Re: Case Re: 323761 – Cooloo Wind Farm

Applicant : Neoen Renewables Ireland Limited

Site Location: Located within the townlands of Cloondahamper, Cloonascragh, Elmhill, Cooloo, Lecarrow, Dangan Eighter, Lissavally and Slievegorm, Co.Galway

Map 15: Wind Potential (This map can be viewed at a larger size on <http://galwaycoco.maps.arcgis.com/apps/webappviewer/index.tbc>)

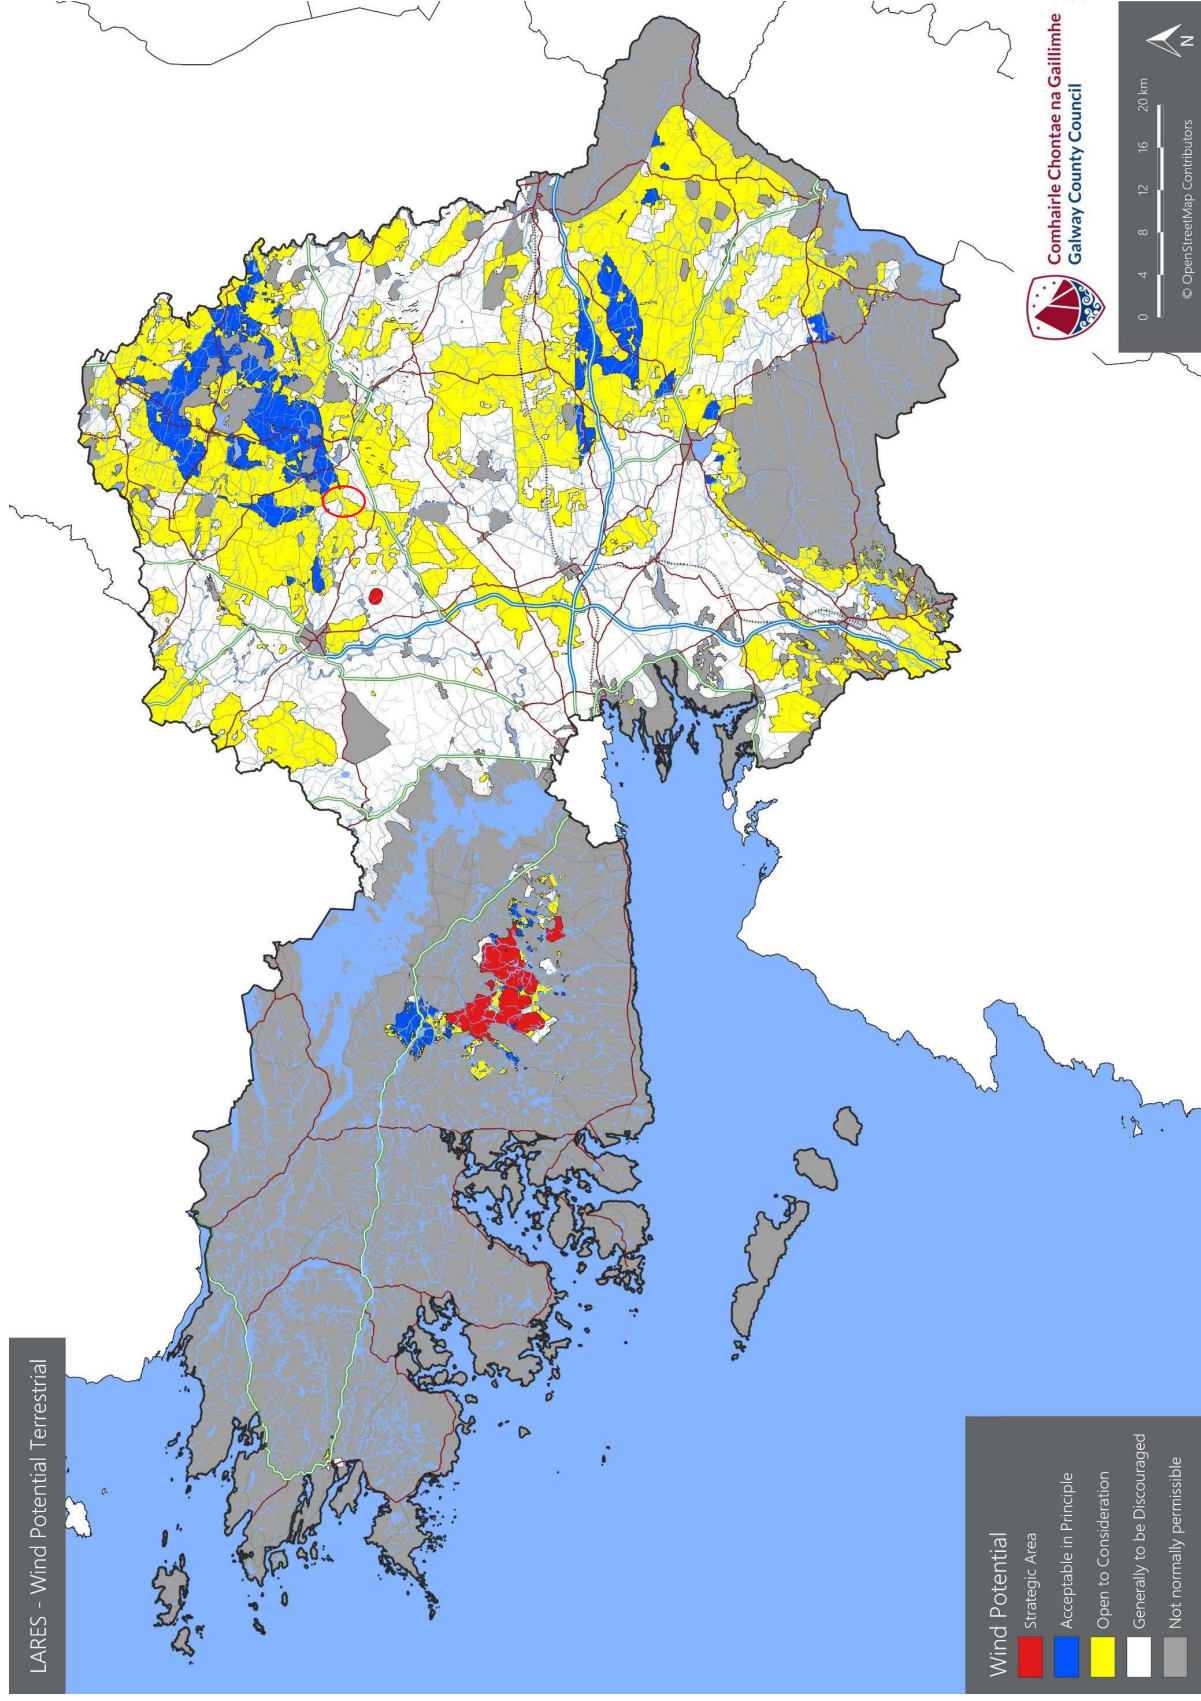
Turbines 6, 7 and 8 are in areas that are termed “generally to be discouraged” by the Galway County Council Wind Potential report. The image below clearly shows the position of Turbines 6, 7 and 8, and that they are in the area termed “generally to be discouraged”.

Turbines 6, 7 and 8 are integral parts of the proposed project. In order for this project to be classified as a Strategic Infrastructure Development, it must meet the 50MW threshold. Without turbines 6, 7 and 8 which are clearly located in areas that are termed "generally to be discouraged" this project's generating capacity reduces to the range of 36MW to 42MW which is well short of the required 50MW that is required to classify it as a Strategic Infrastructure Development.
